**SSD 9809 New Marsden Park Public School**

Thank you for your correspondence via Major Project portal (ref: PAE-800) on 18 October 2019, requesting Transport for NSW (TfNSW) to review and comment on the above.

CD19/08438

Drawing Title
SITE PLAN - TEMPORARY SCHOOL LAYOUT

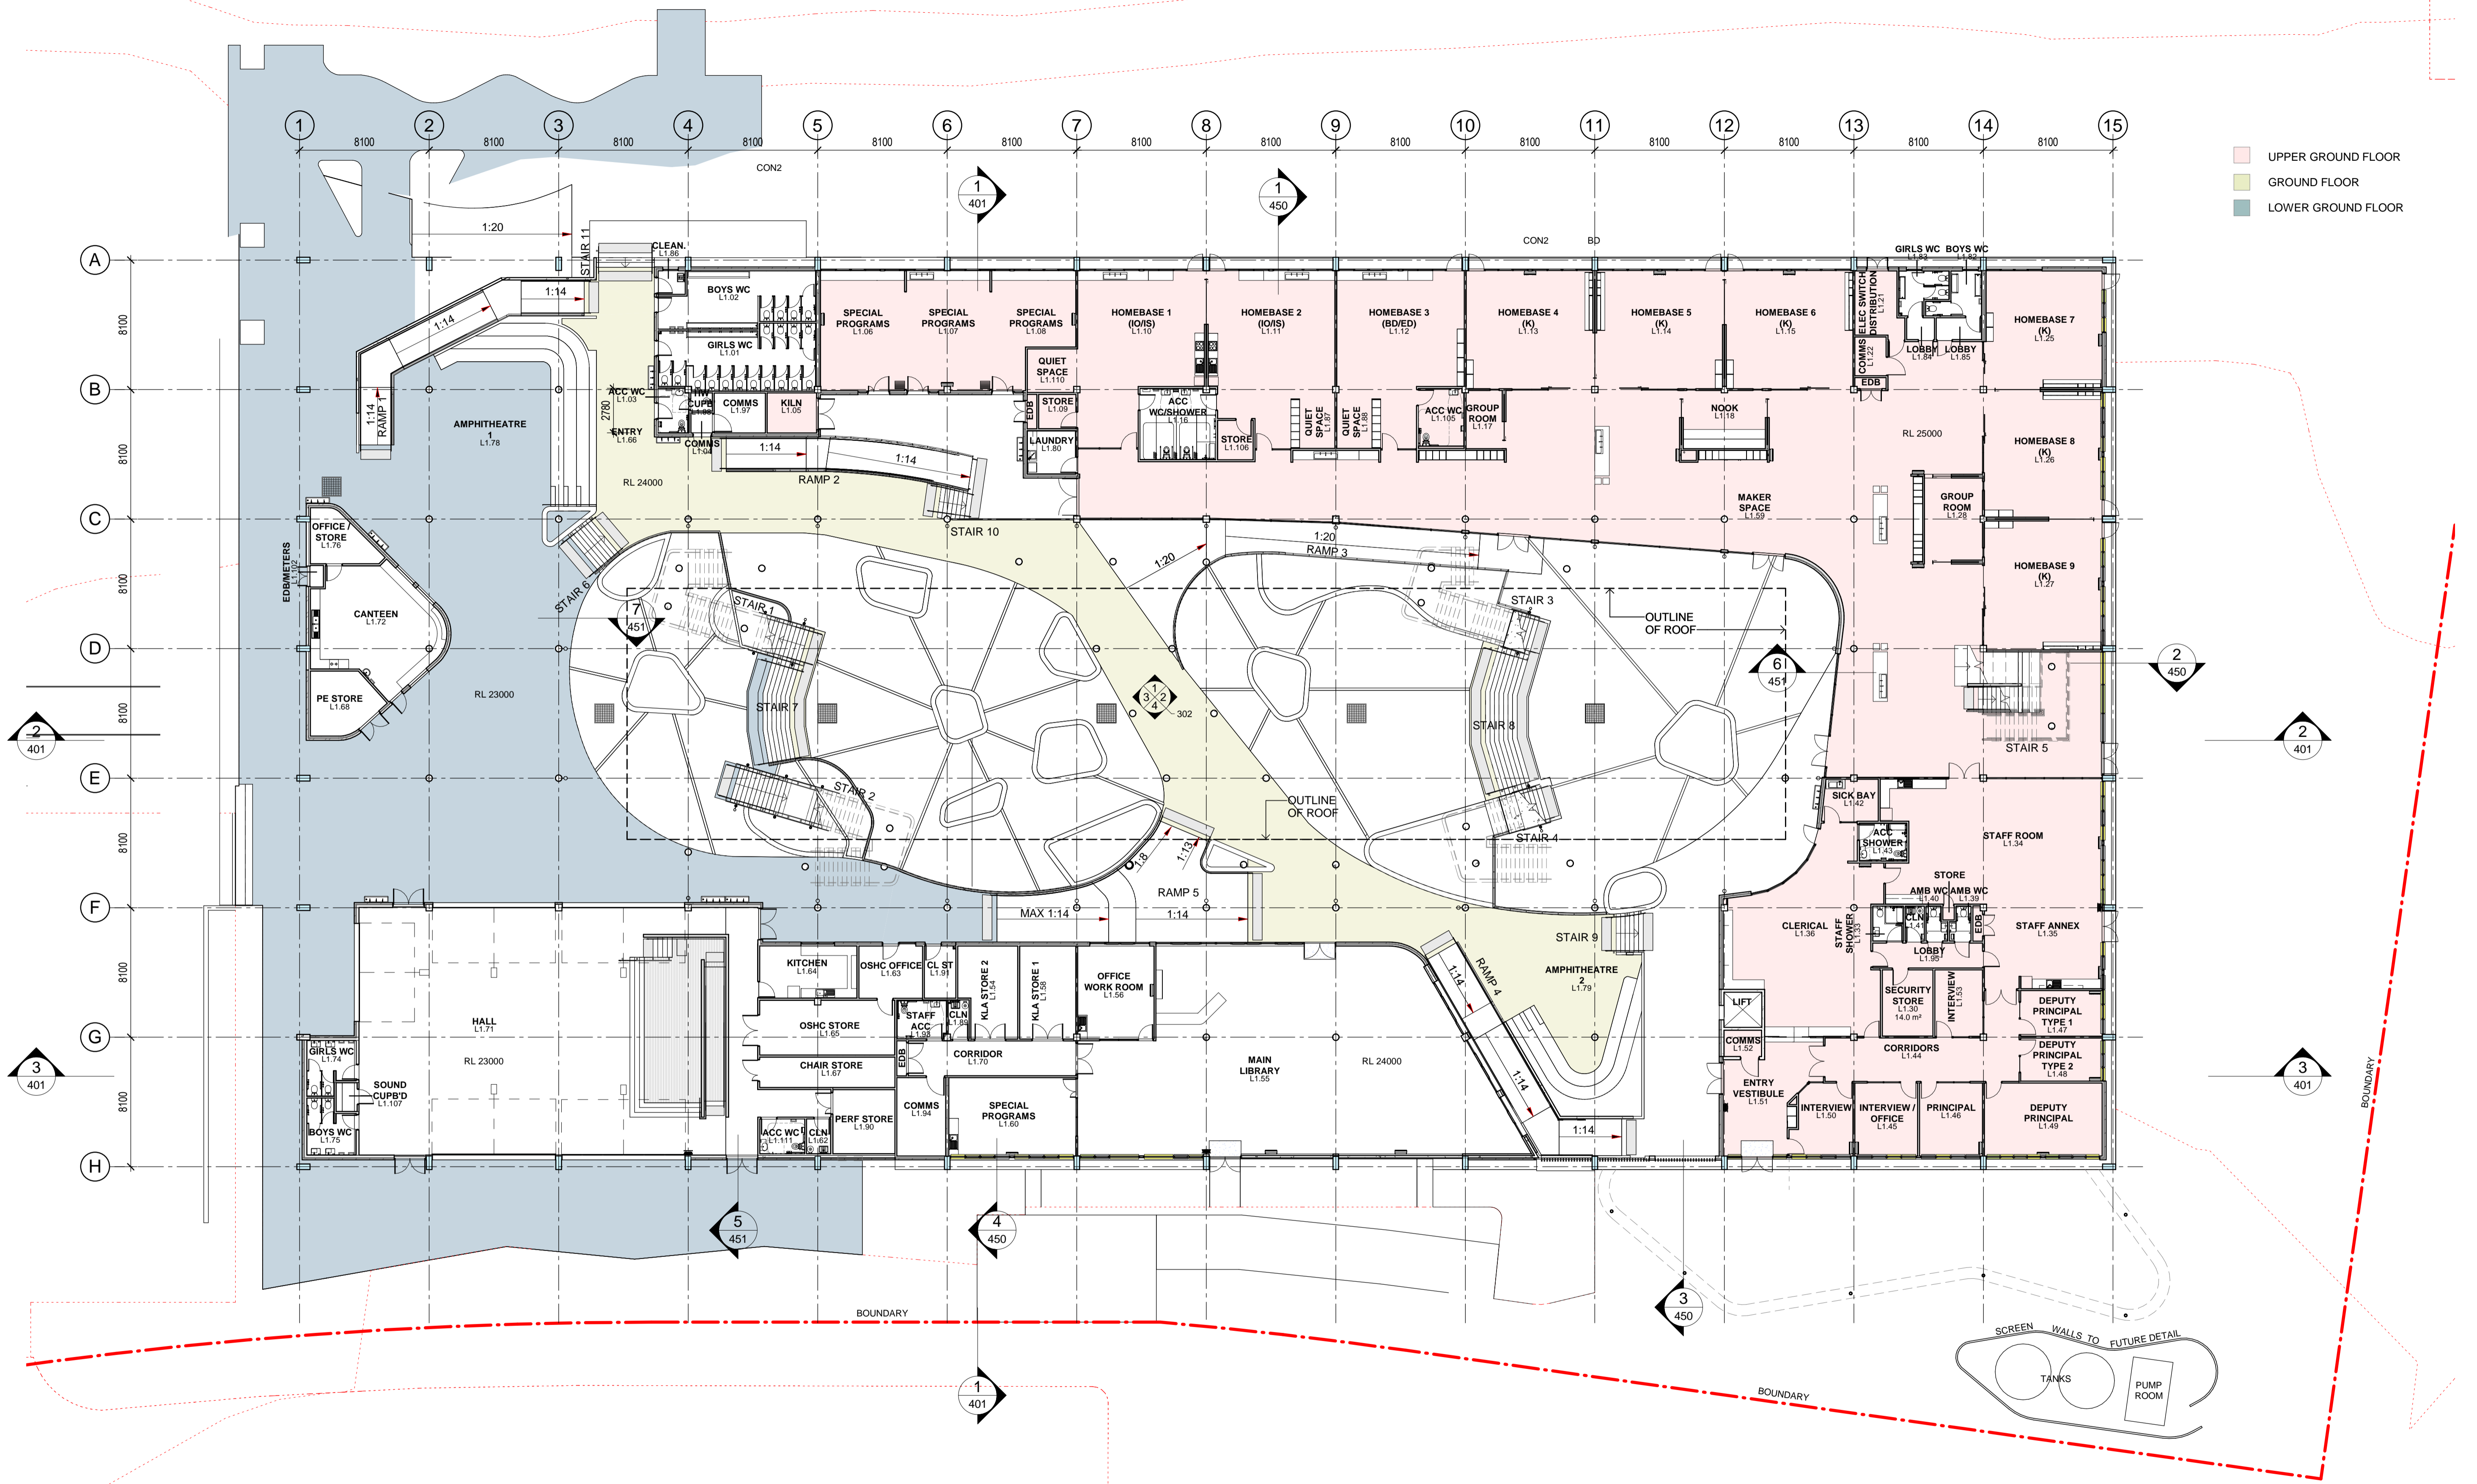
- Architectural Drawing Title: Site Plan – Temporary School Layout (Drawing Reference 19154-NBRS-A-052) shows that pick-up/drop-off area is proposed on Beale Street to the west of the school site. There is no indication of whether this provision would also be used for bus pick-up/ drop-off.

- Bus pick-up and drop-off lay-by is proposed on Bolwarra Drive to the north of the school site. No pedestrian access is proposed at the north of the school site in both of the temporary school (*Architectural Drawing Title: Site Plan – Temporary School Layout; Drawing Reference 19154-NBRS-A-052*) and the permanent arrangement (*Architectural Drawing Title: Site Plan – Access Diagram; Drawing Reference 19154-NBRS-A-051*).

Further review should be undertaken on the proposed pick-up/drop-off location in consideration of trip distribution perspective to alleviate the traffic demand on the section of Northbourne Drive fronting the school site, noting that Northbourne Drive would likely to service public bus route in the future. Clarity should also be sought in regards to how the proposed bus bays on Bolwara Drive could be accessed by the students to/from the school. The above recommendations are applicable to both the temporary and permanent arrangement. The length of the pick-up/drop-off laybys, including the bus layby, should be indicated on the relevant drawings for information.
